Permit No: 01-0377

Proposed Project Description: New duplex
Action: Approved Approved with Conditions Denied
Signature: _____
Date: _____

DATE: 24 July 2000 ADDRESS: Lot #16 Maggie Lane CBL: 292-A-036

Valuation: \$100,000.00 Plan Review # 1132/2K.
 Fee: \$624.00 Date: 24 July 2K
 Building Location: LOT 46, Maggie Lane. CBL: 292-A-036
 Building Description: 2 Family Dwelling
 Reviewed By: S. Hoffses

Drawing Name: Space & Bulk Requirements Lot 16
Project: MAGGIE LANE, PORTLAND

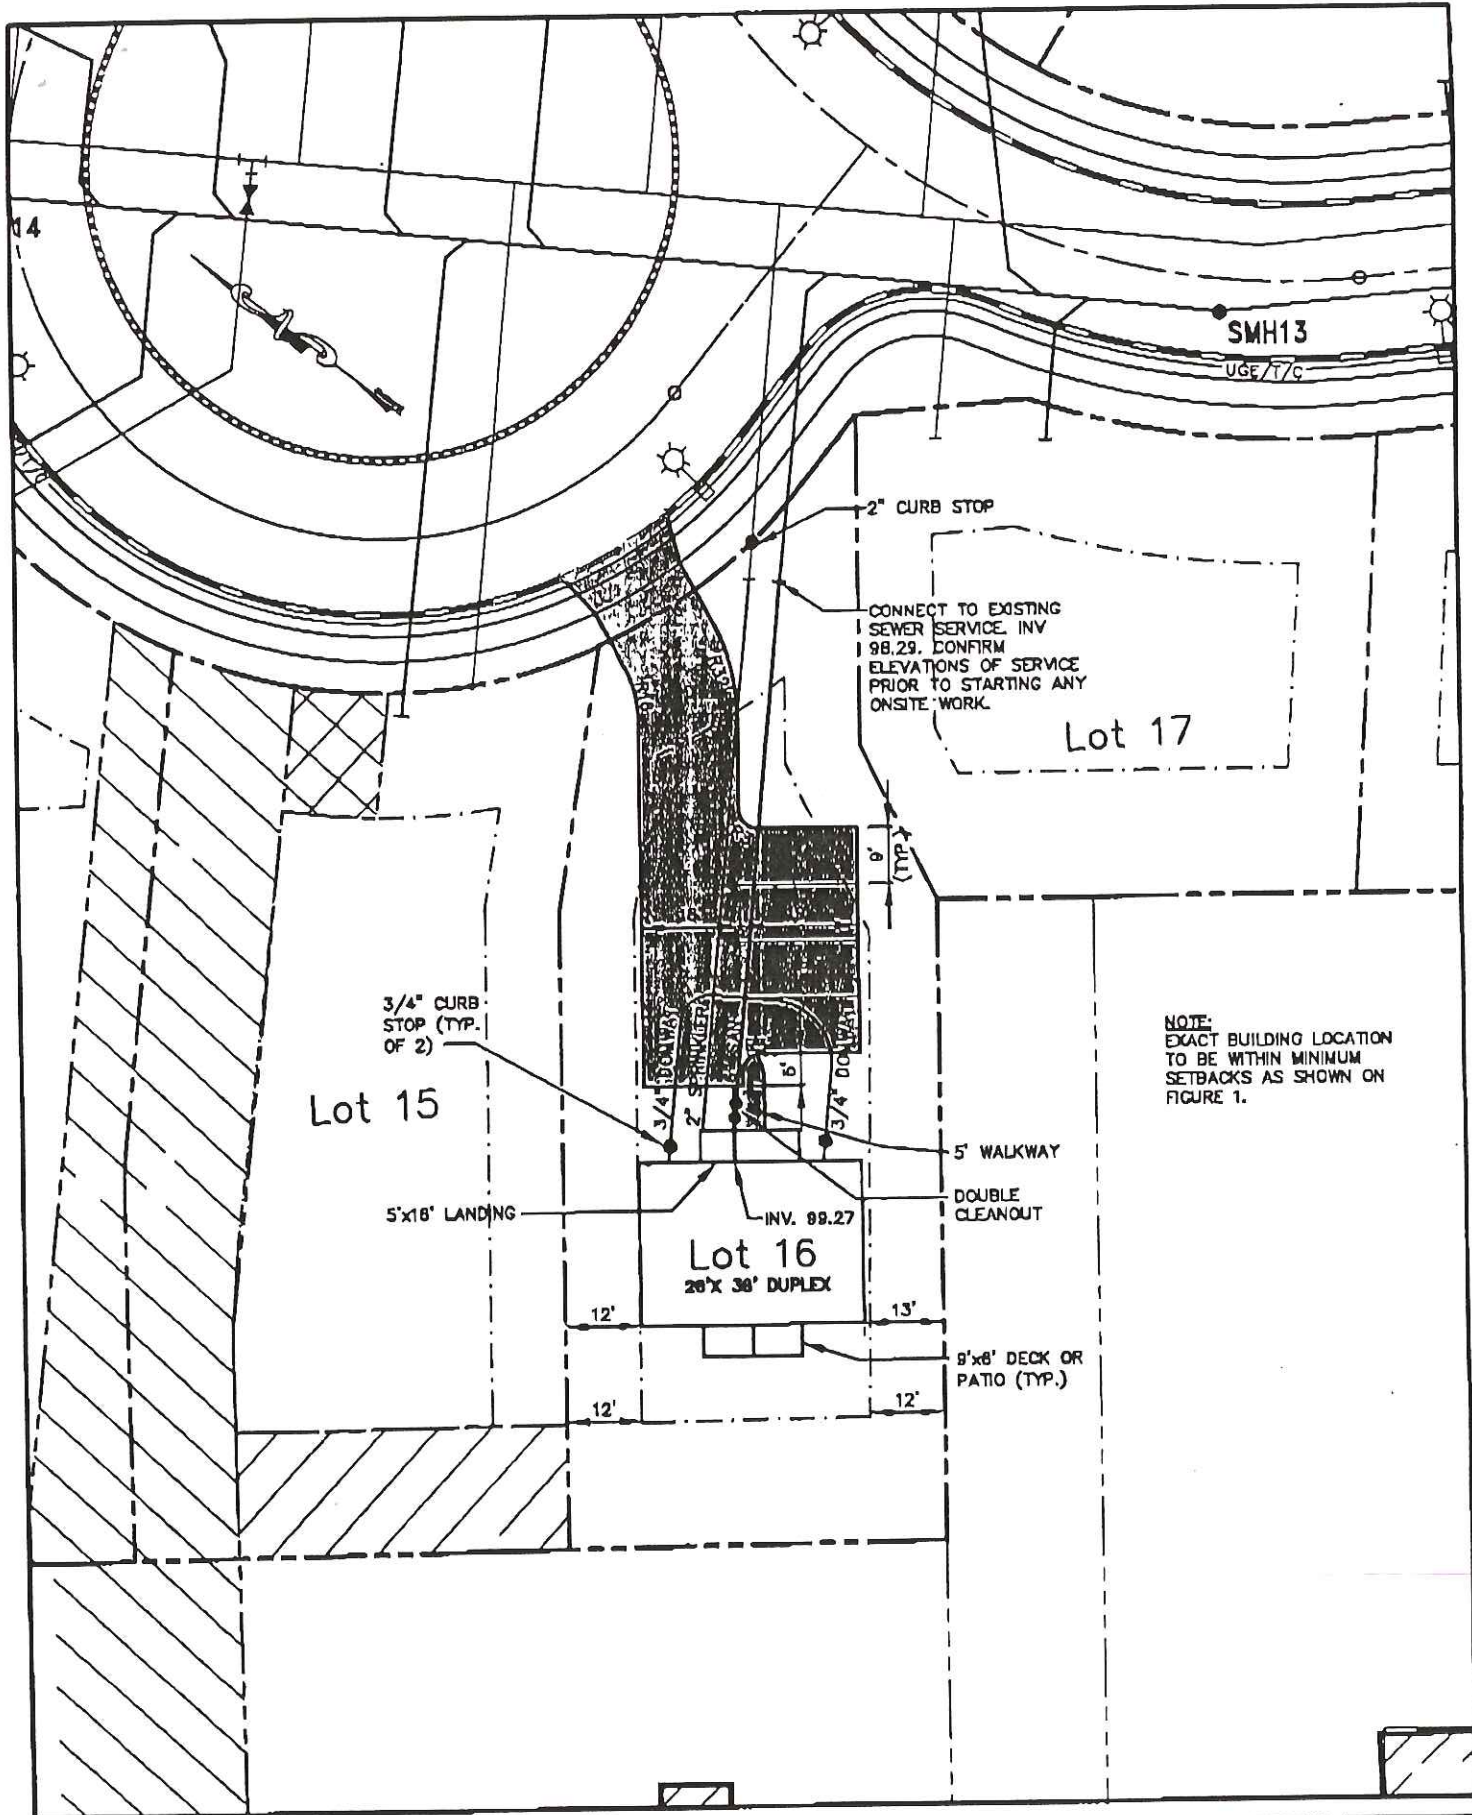
Lot Street Frontage - 50' req - 50' shown

Front Yard - 20' min - 20' shown

Rear Yard - 20' min - 20' shown

Side Yard - 12' req - 12' & 13' shown

Drawing Name:  
**Layout & Utilities-- Lot 16**  
 Project:  
**MAGGIE LANE, PORTLAND**

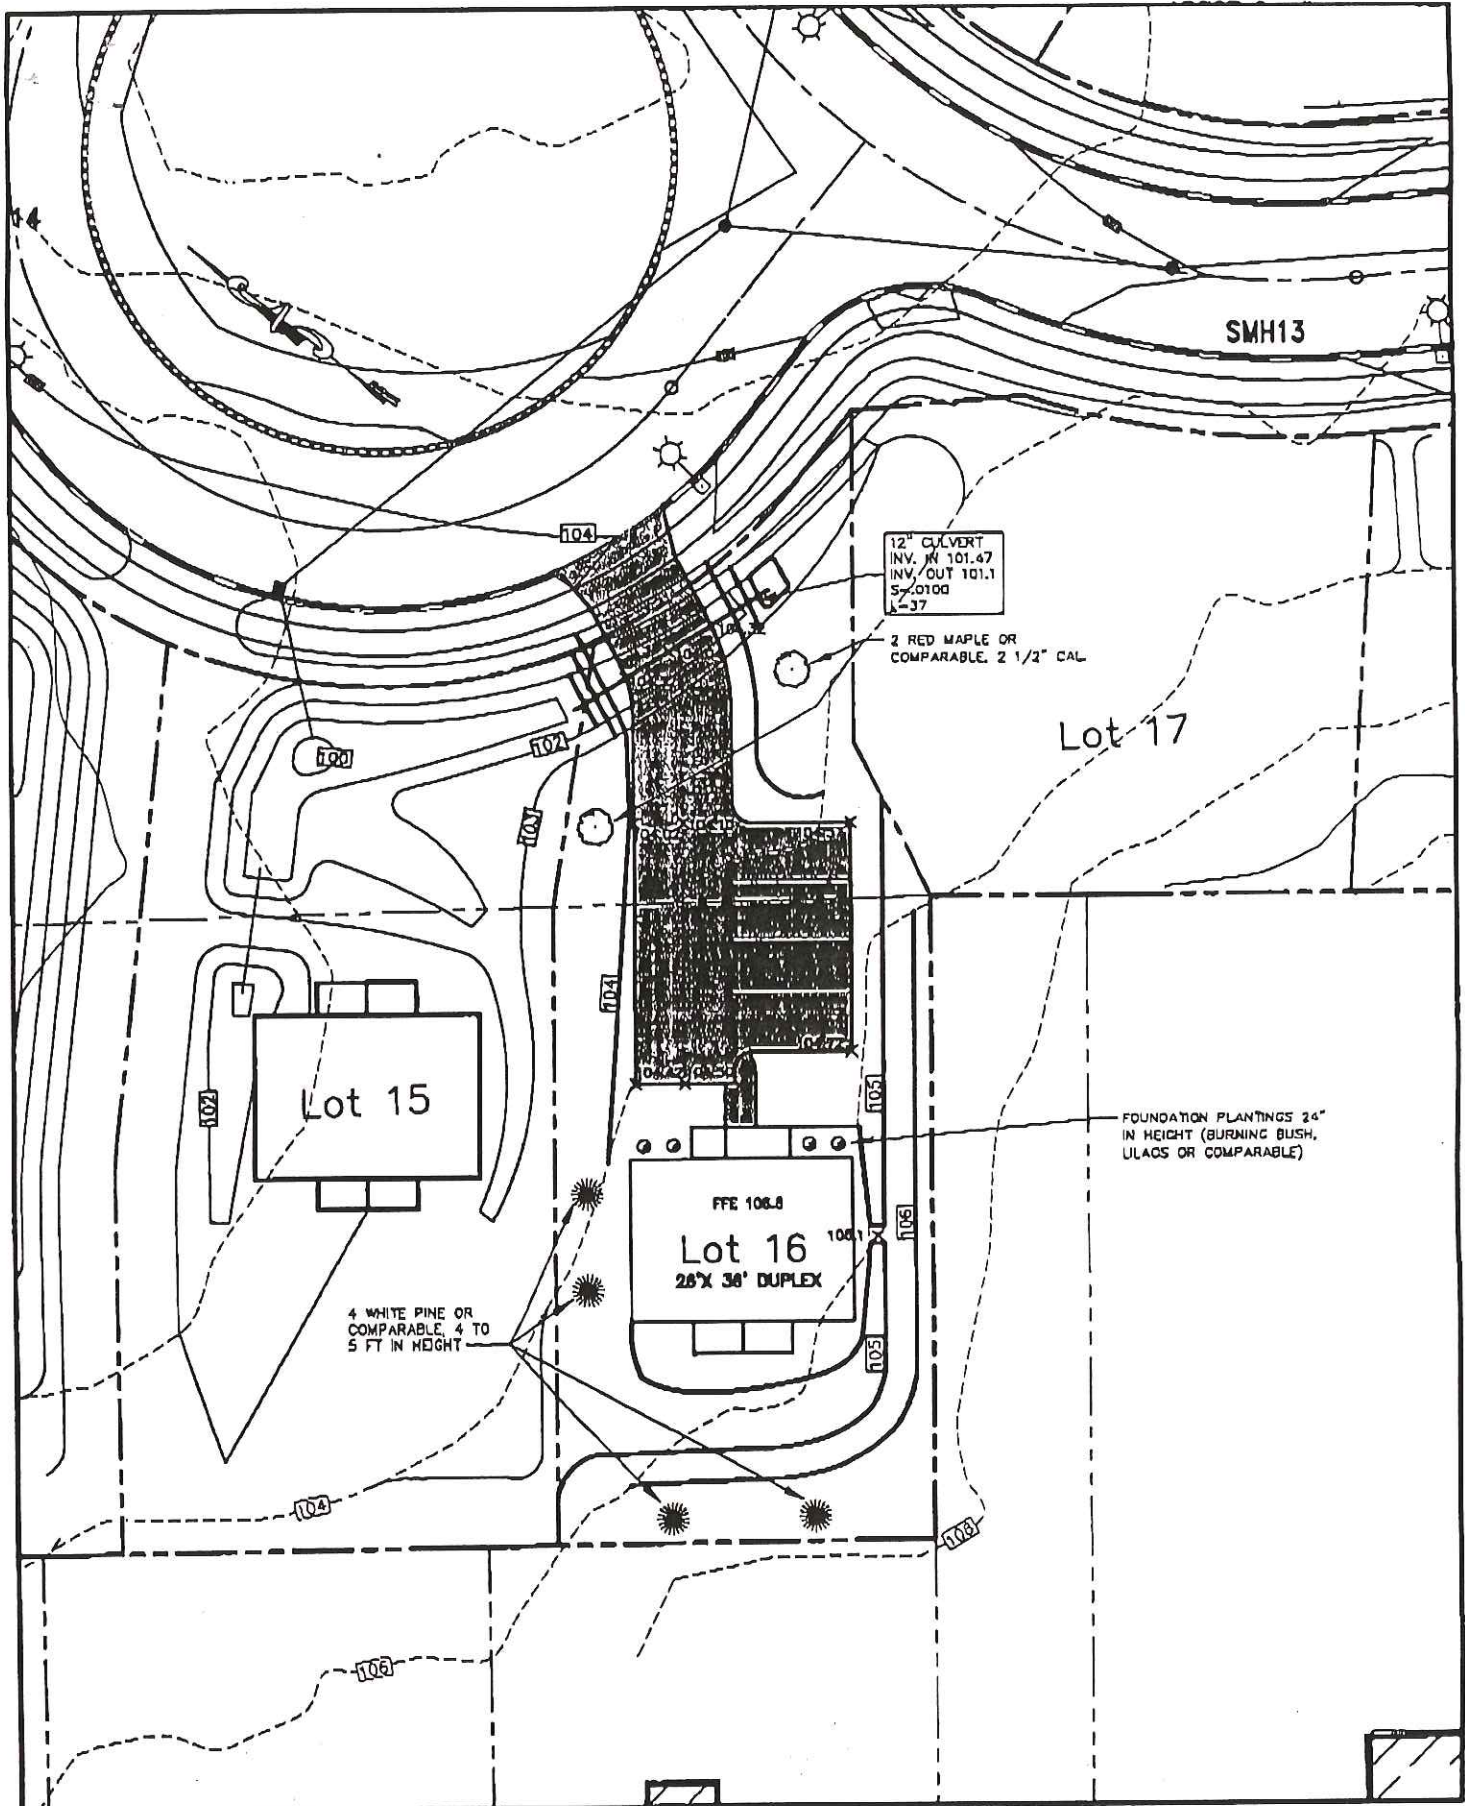
- 6 Show all utility connections: water, sanitary, sewer, storm drain, electric, telephone, cable.
- 7 A sewer permit is required for you project. Please contact Carol Merritt at 874-8300, ext . 8828. The Wastewater and Drainage section of Public Works must be notified five (5) working days prior to sewer connection to schedule an inspector for your site.

Drawing Name:  
**Grading & Drainage - Lot 16**

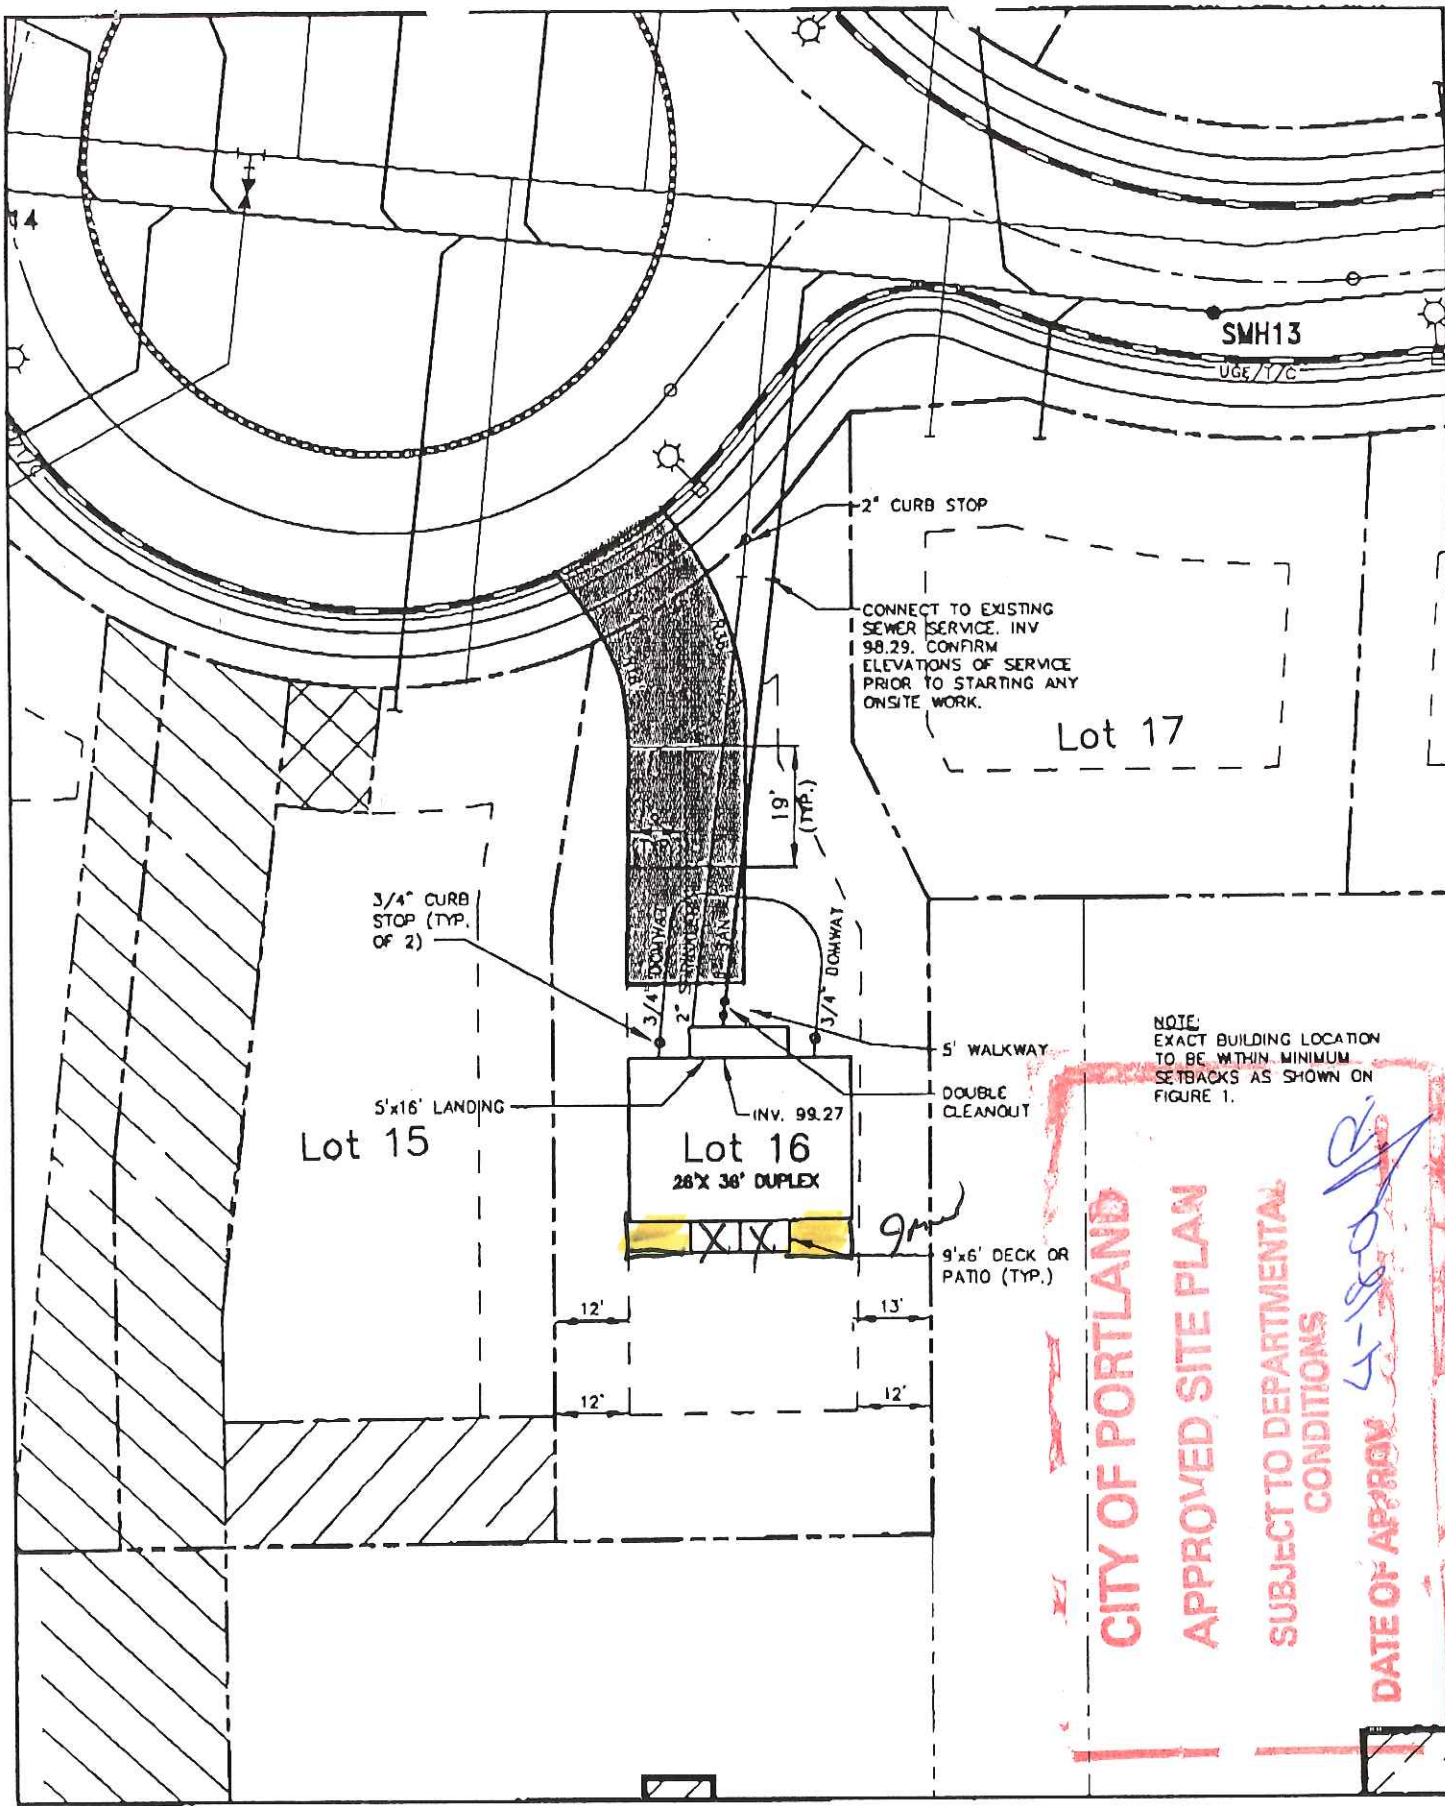
- 9 The building contractor shall check the subdivision recording plat for pre-determined first floor elevation and establish the first floor elevation (FFE) and sill elevation (SE) to be set above the finish street/curb elevation to allow for positive drainage away from entire footprint of building.

- 10 The site contractor shall establish finish grades at the foundation, bulkhead and basement windows to be in conformance with the first floor elevation (FFE) and sill elevation (SE) set by the building contractor to provide for positive drainage away from entire footprint of building.

14 The site grading shall be accomplished to avoid any ponding of water or concentrated flow of runoff onto adjacent properties.
